Application No: Y/98/20/PL

Site Address: Bonhams Field Main Road Yapton BN18 0DX

Description of works: Erection of 75 No. dwellings with associated parking, public open space & the creation of a new vehicular access. This application affects the character & appearance of the Main Road/Church Road Conservation Area & affects the setting of listed buildings.

Thank you for your internet representation made on 12th October 2020 which has been recorded as an objection with the comments as follows:

The proposed layout of the scheme subject to this submission for planning permission.

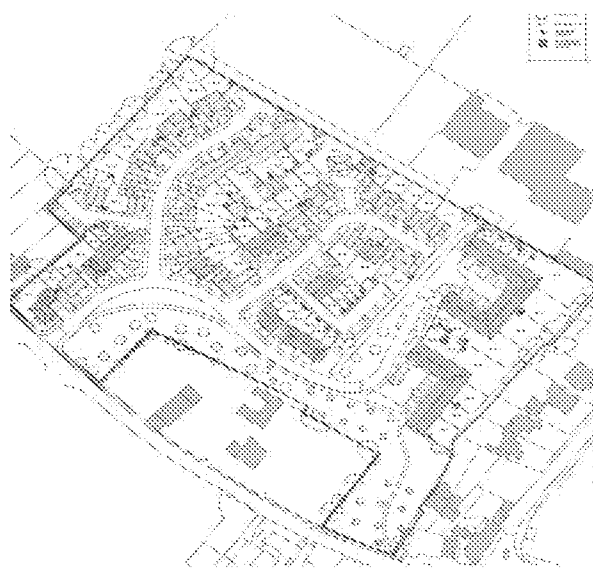
The Panel remain of the view that development fronting and in close proximity to Yapton Road (eg plot no's 1 and 2) will detract materially from the rural approach into the Yapton Conservation Area.

The proposed house fronting Main Road (plot 1) is 'housing estate like' and over-dominant. It also has an untypical fenestration treatment. A simpler, good quality, design in high specification materials and finishes, appropriate to the rural setting is required, if permission is to be granted for development in this very sensitive location.
